CROSSPOINT CENTER

CONDITIONAL MASTER PLAN

CHARLOTTE-MECKLENBURG PLANNING COMMISSION
INTER-OFFICE COMMUNICATION

SUBJECT: Administrative Approval for Petition #89-76 by Crescent Land and Timber, Tax Parcel #041-101-02, 04, 09

**CONDITIONAL MASTER PLAN**

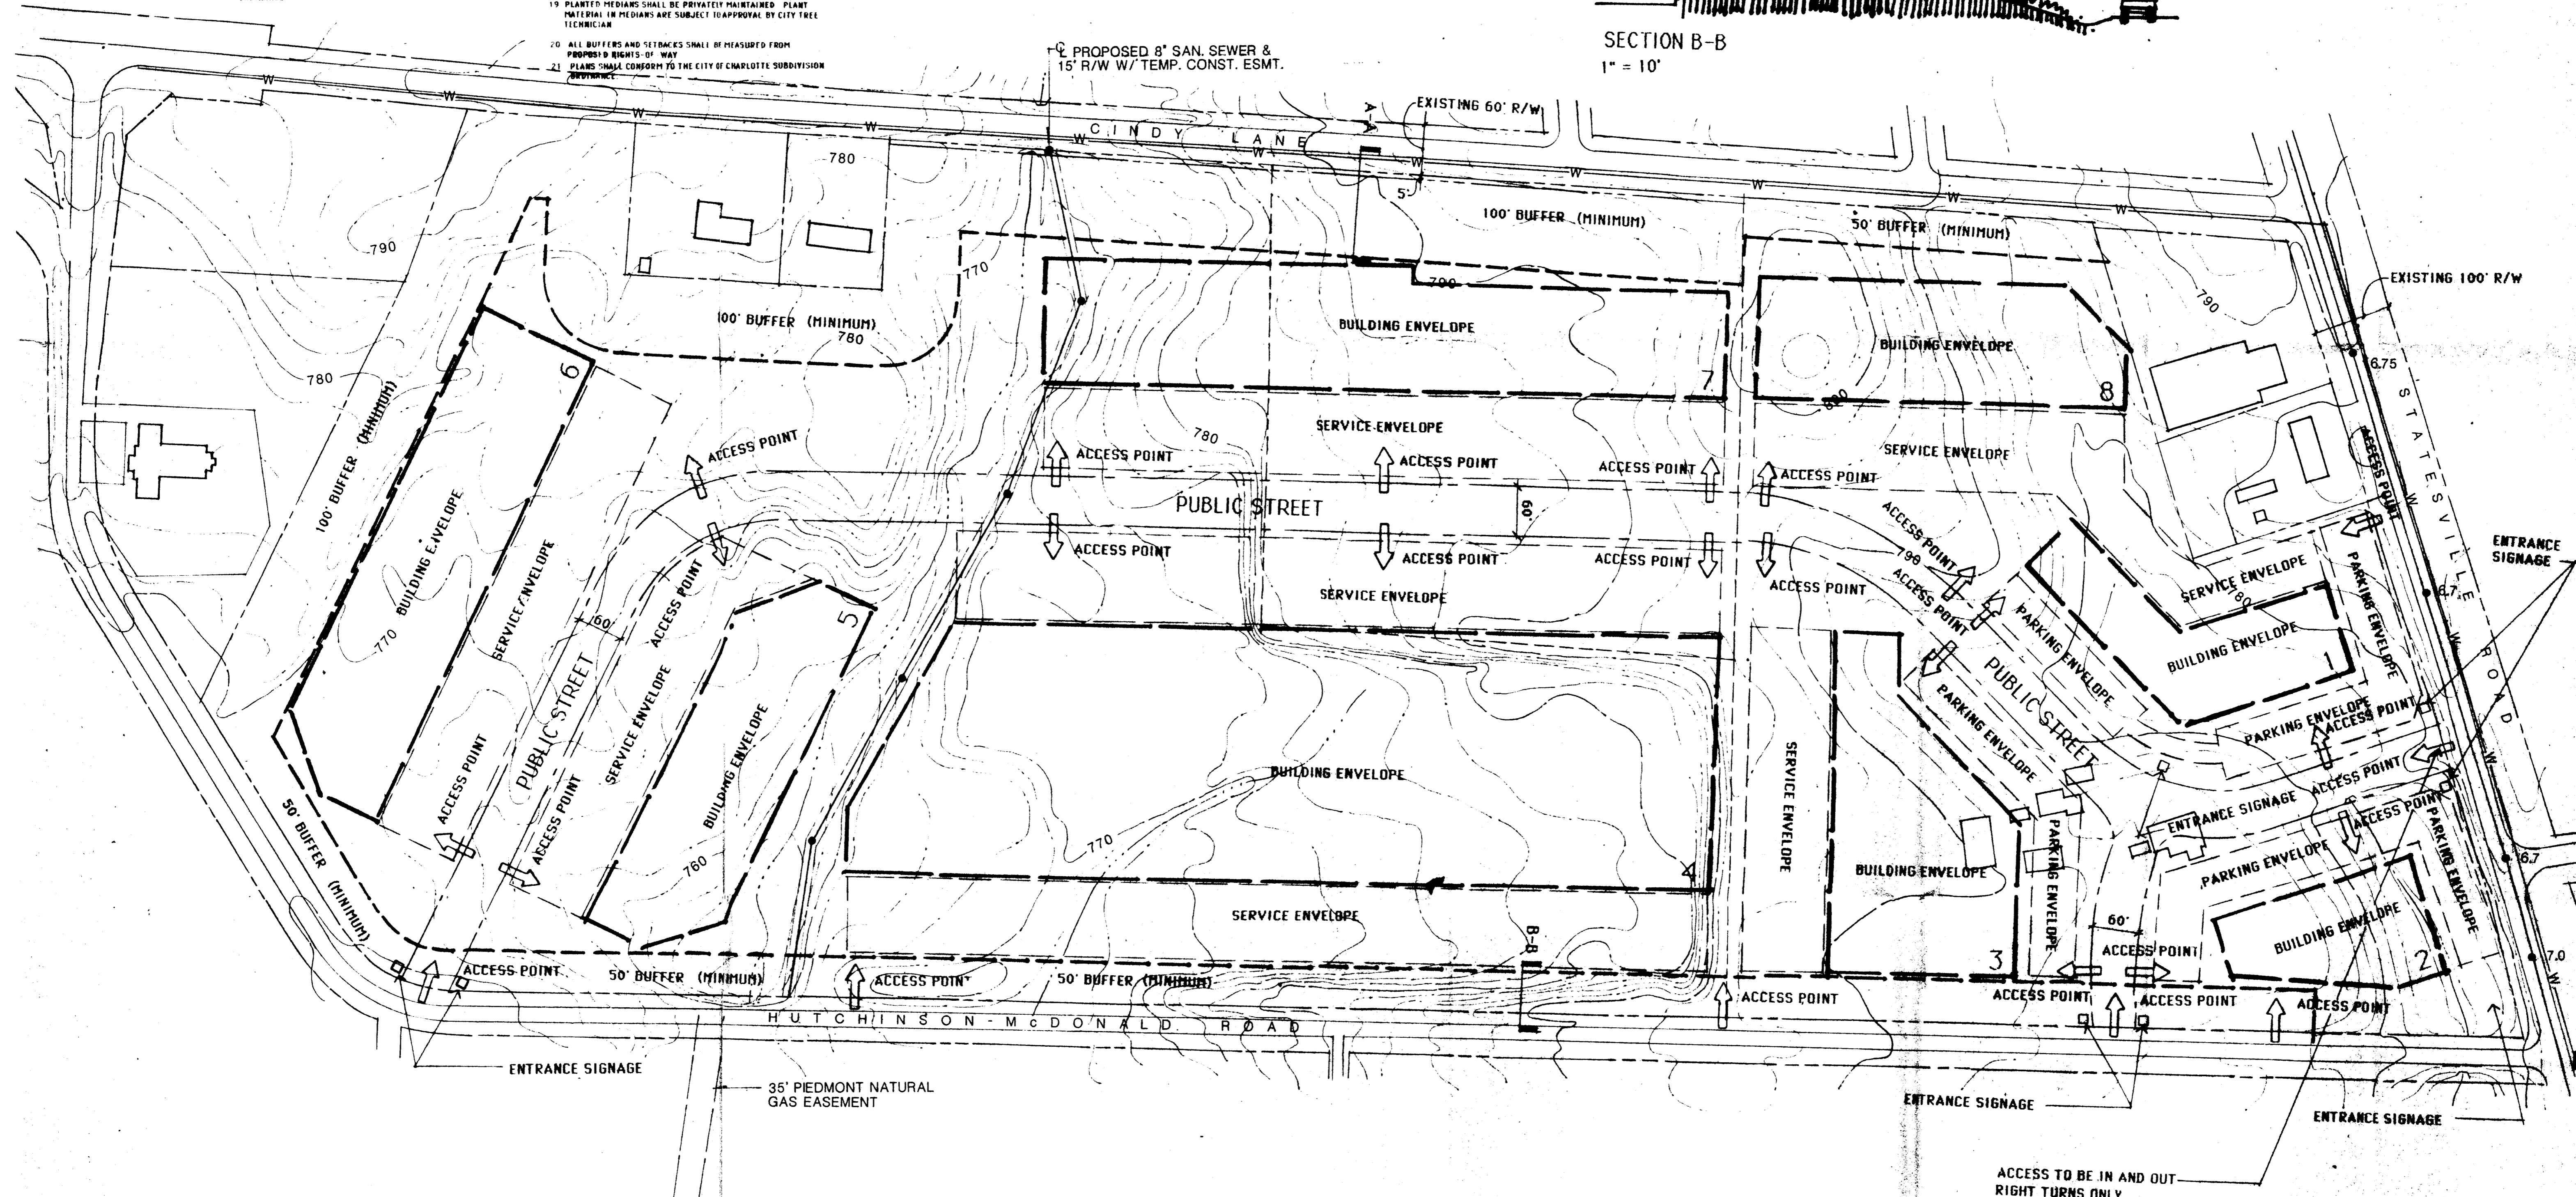
Attached is a revised plan for the above mentioned rezoning petition. The plan has been revised to consolidate the eight building areas into five building areas with a total of 786,000 square feet of building area. We have also allowed the developer to revise the notes regarding the buffers to allow him to place berms in these buffers where the existing vegetation is sparse to non-existent. Since these changes are minor in detail and do not reduce the exterior yards, I am administratively approving this plan. Please use this plan when evaluating requests for building permits.
